Former Nestle Factory, Hayes – Ref: 1331/APP/2017/1883

Conservation & Design Advice – Schedule One

Barratt London & SEGRO Design Team Response

**ILLUSTRATIVE ELEVATION UNIT 1**

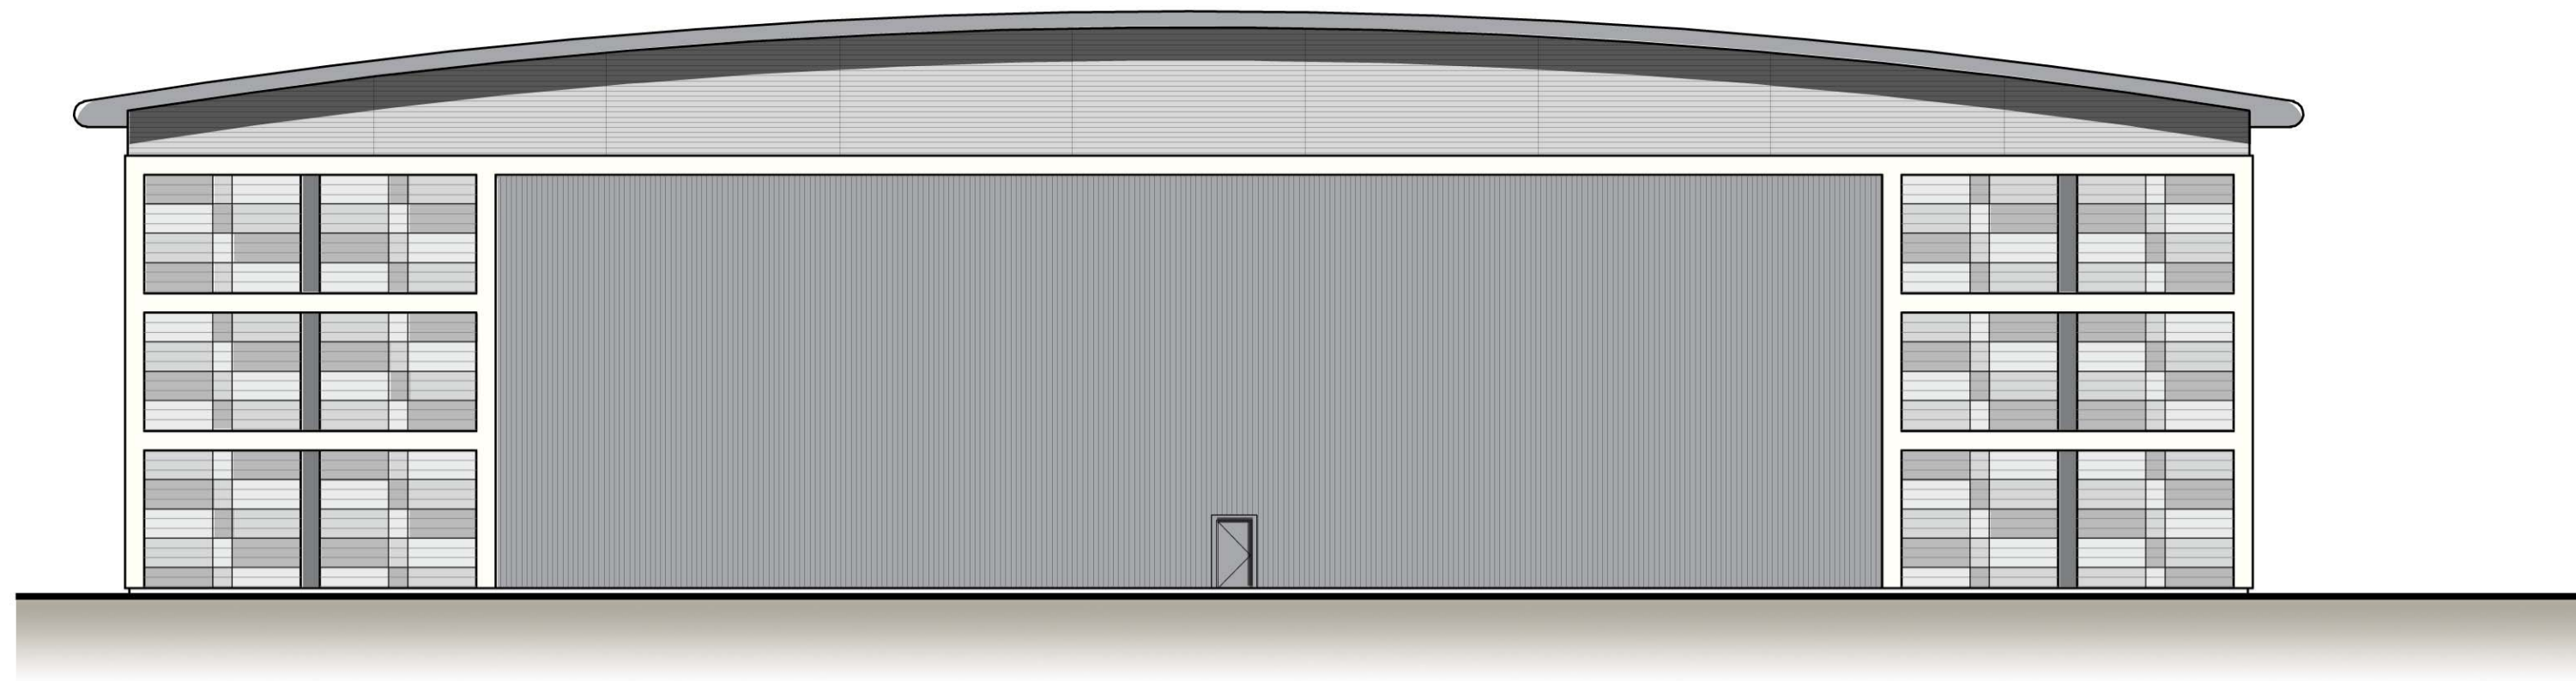
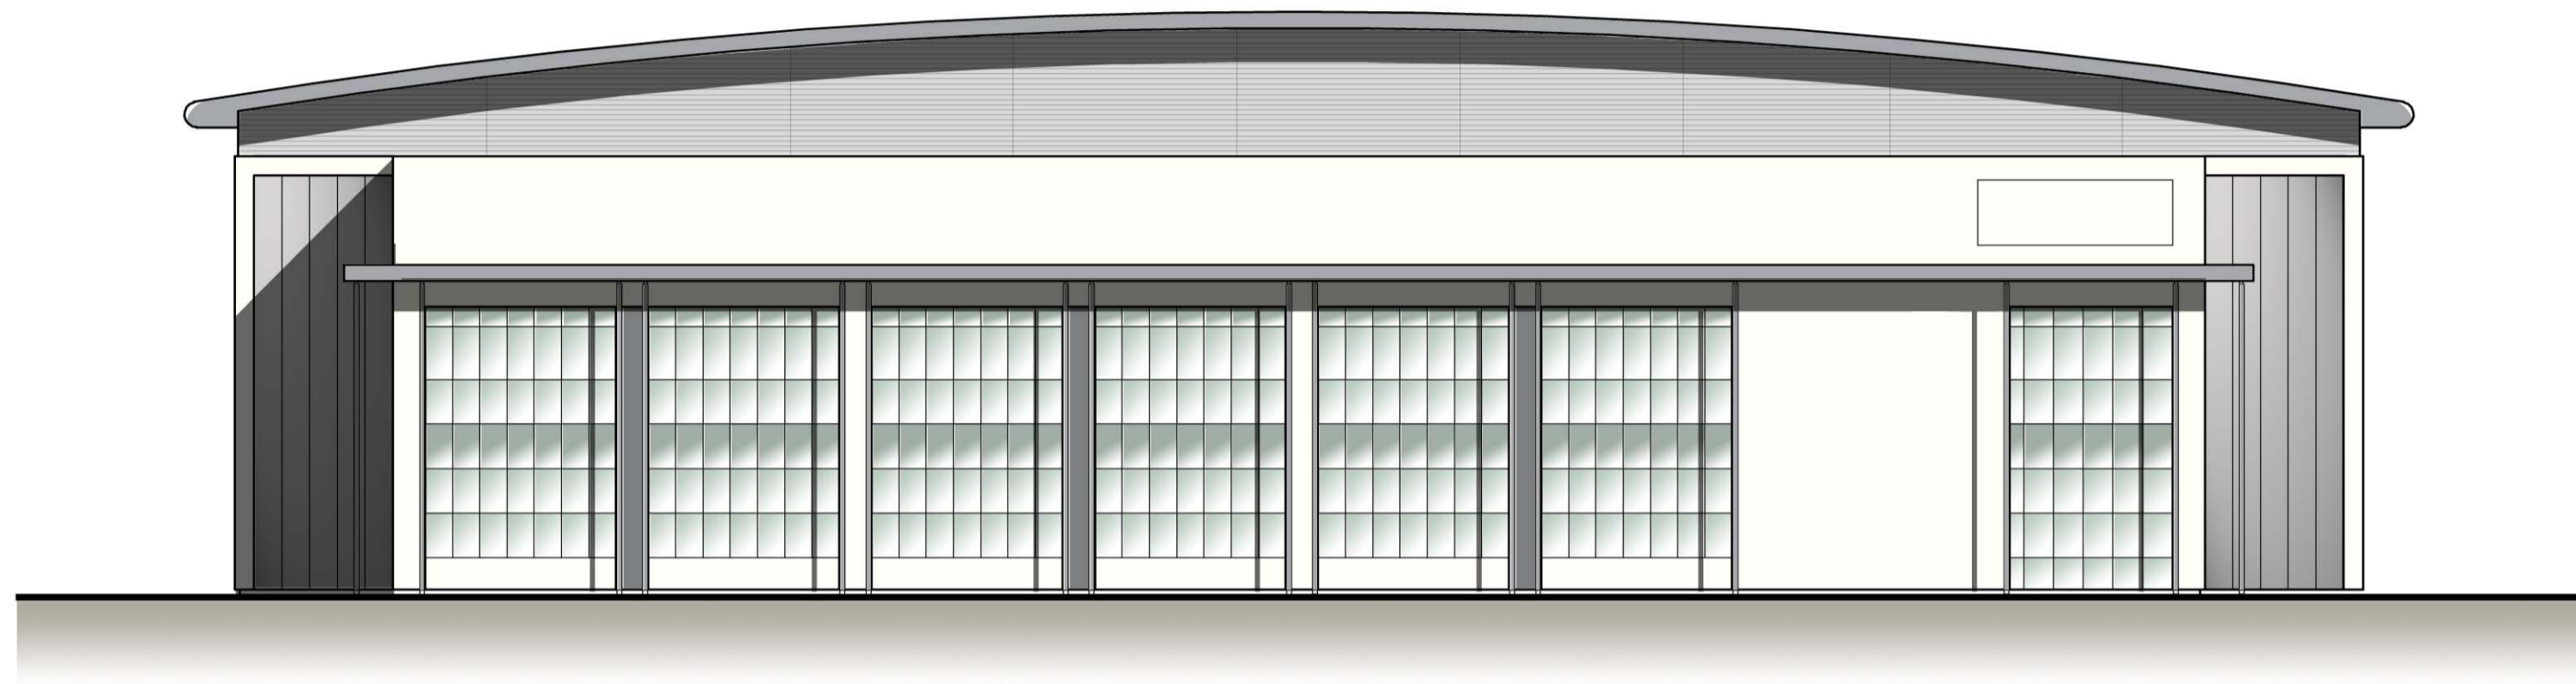
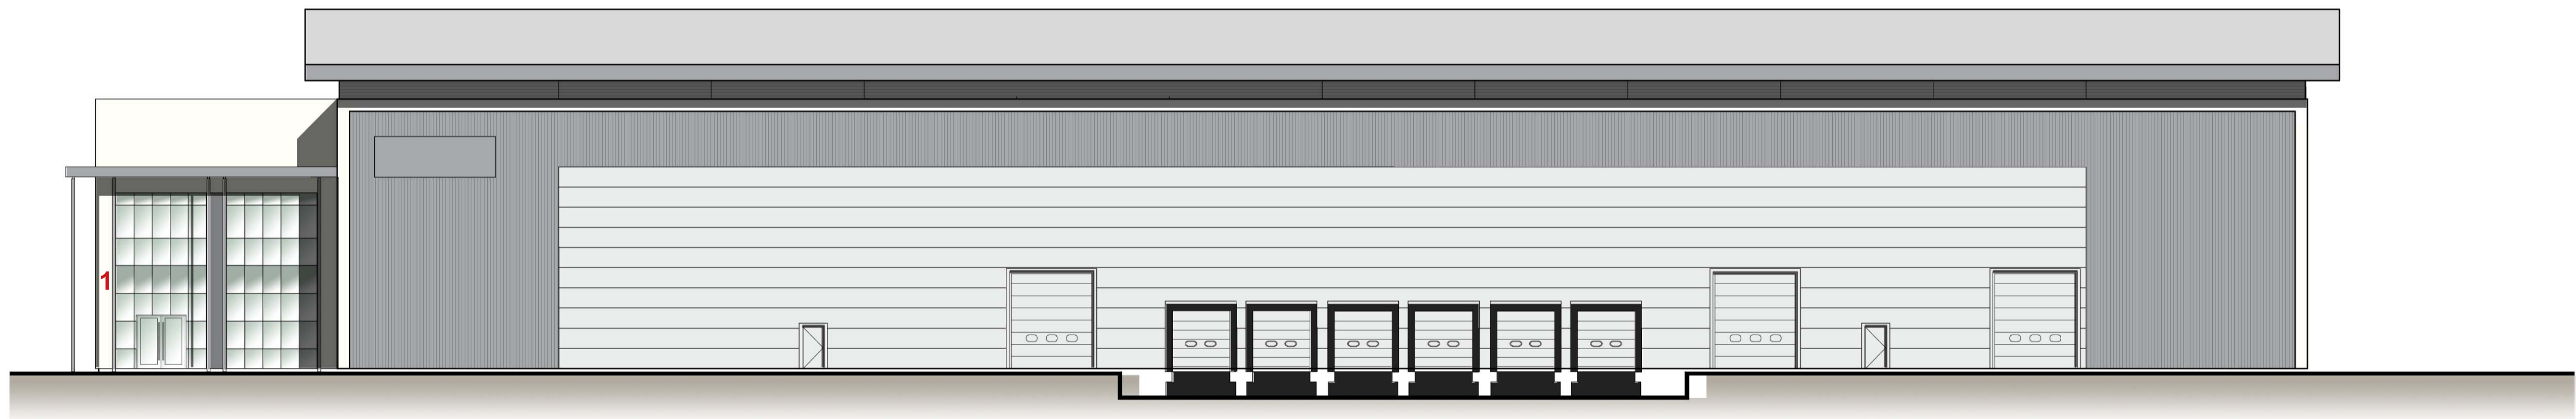
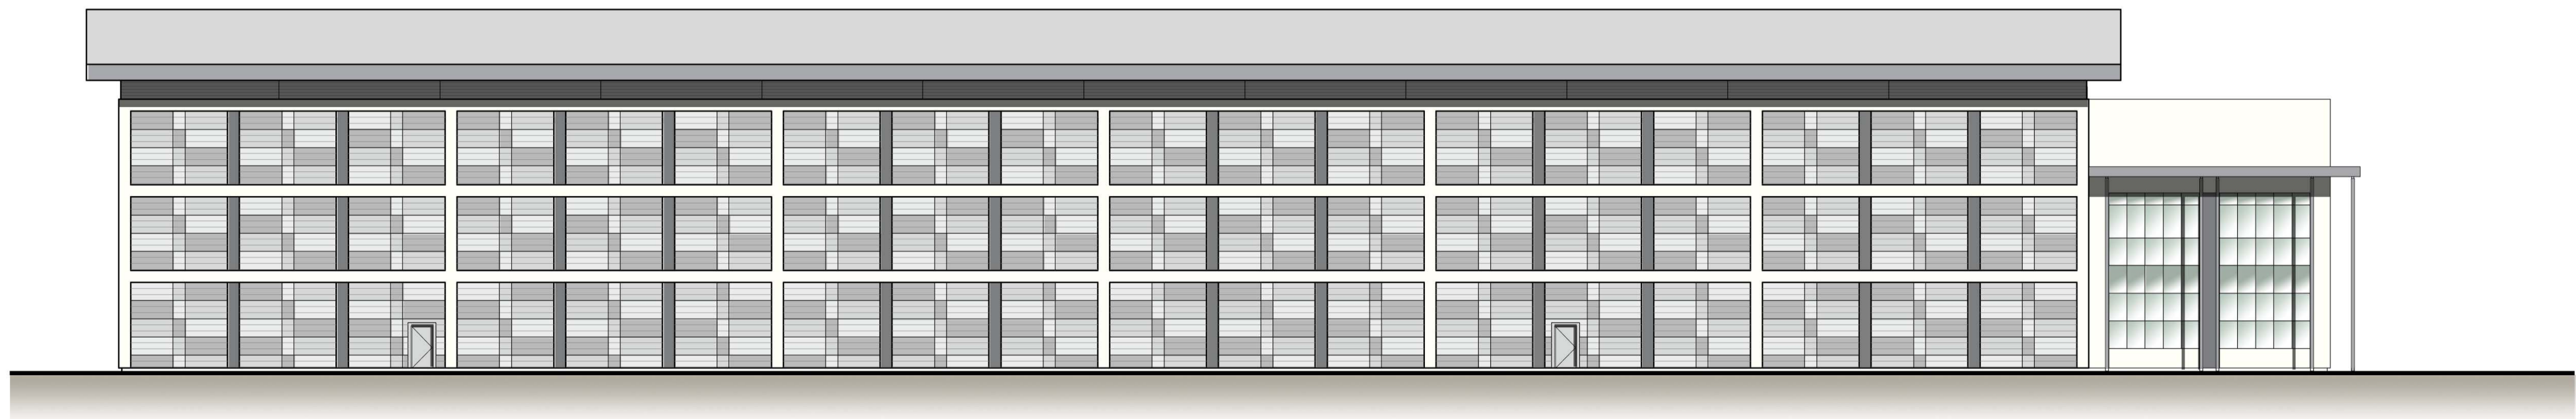
32.	Unit 1 needs a better detailed elevation onto Nestle Avenue, a green wall? The northern elevation of unit 3 needs to look more like unit 1 and relate better to the original factory design. All of the units should have green roofs.	Response to follow.

**RESIDENTIAL ELEVATIONS**

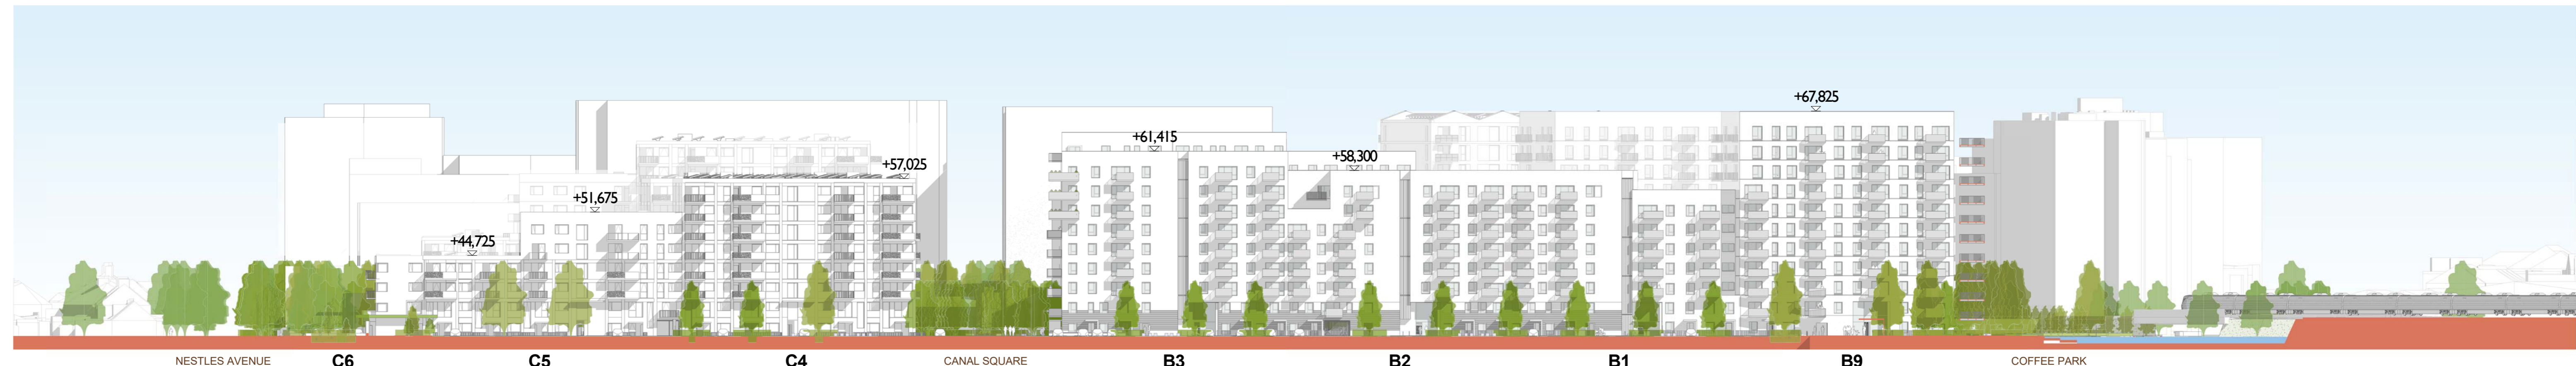
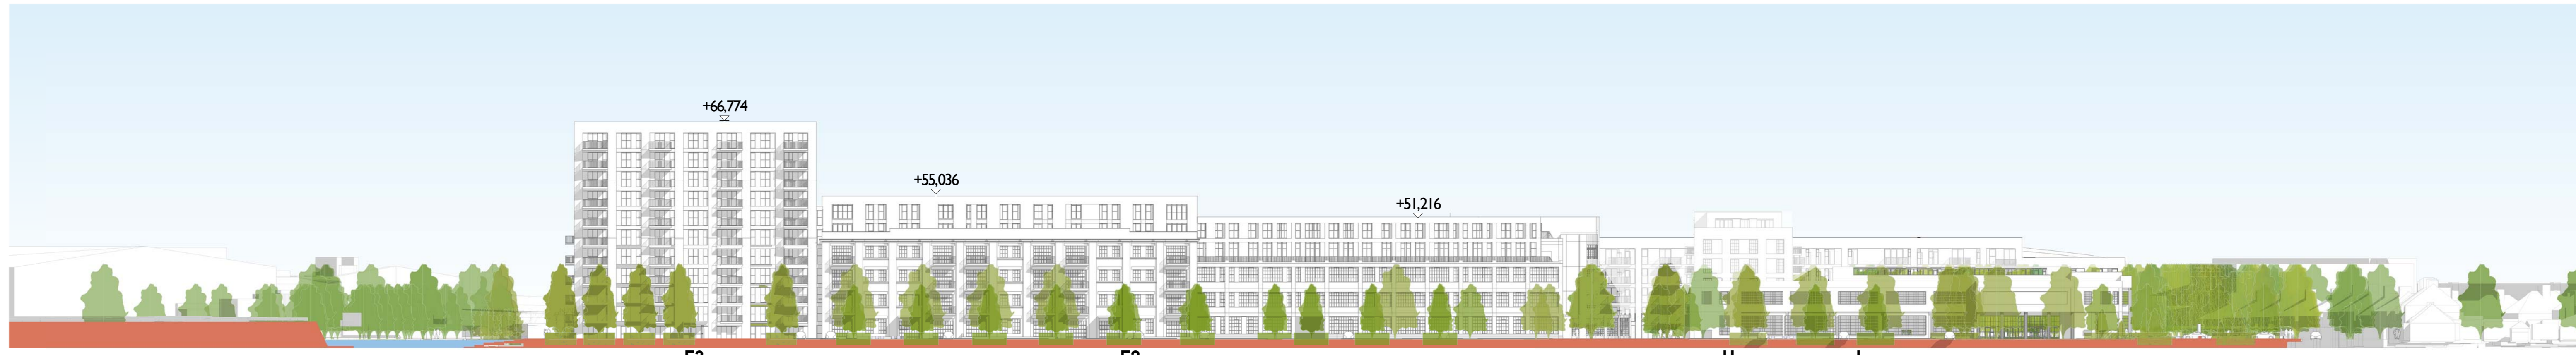
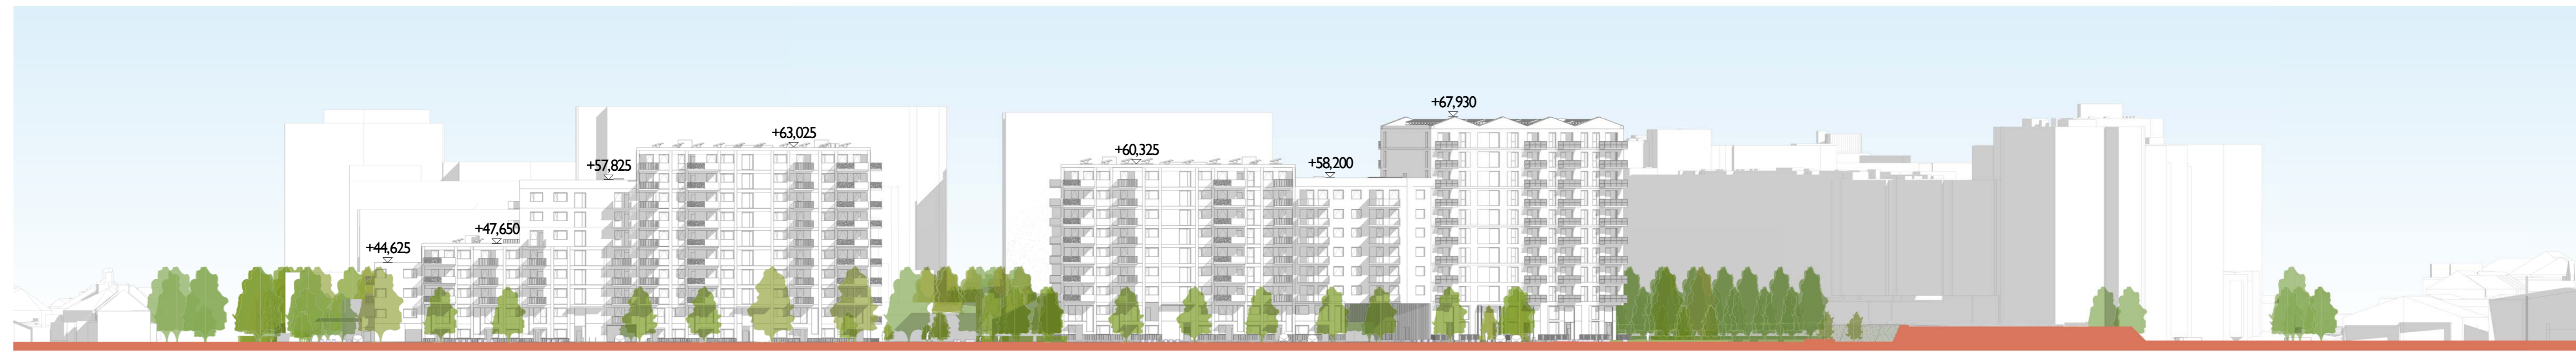
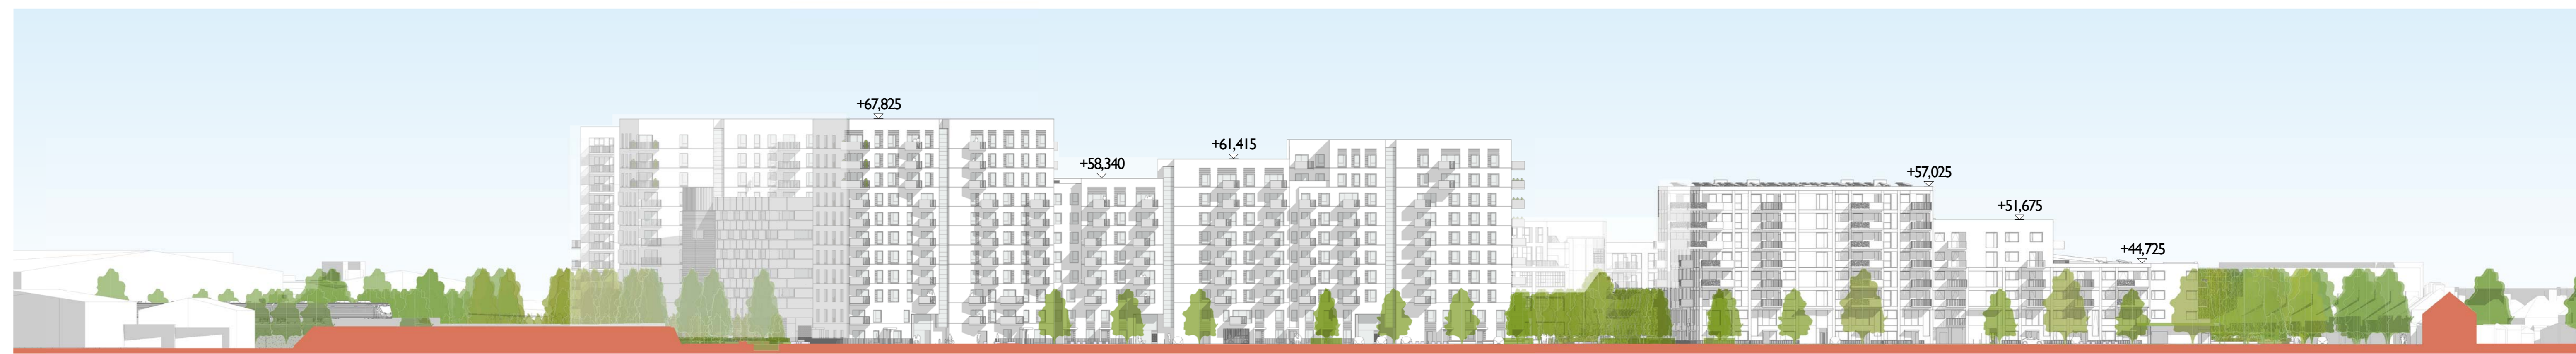
14.	<p>The townscape study clearly illustrates the impact of the proposed development on long, medium and local views. What is evident from this is the scale of the new development, its massing and height, which rises quite abruptly to 11 storeys behind the Nestles Avenue frontage. It will create a wall of development that will dominate the local sky line when viewed from the existing residential area to the immediate south of the site. There appear to be no views from within the site, particularly angled views from Wallis Gardens.</p>	<p>The heights of the residential blocks rise from G+3 stories on Nestles Avenue to G+10 stories along the railway. This is both to reflect the need for an appropriate level of density, as dictated by the site's increasingly good transport connections once Crossrail is complete, and to respond to the substantial scale of the existing factory buildings which are so essential to the character of the Conservation Area.</p> <p>The massing of the residential buildings within the masterplan is composed as a diverse but unified group; rising to mid height around Sadow Square, reduced in response to the heritage setting of the canteen and main factory front, and maximised along the North edge in the form of four 'feature blocks', fanning out from the orthogonal of the factory to the diagonal of the railway. The skyline is carved and broken up across the project, with multiple breaks at core locations and cutaway terraces; introducing intermediary scale and creating visual accents.</p>
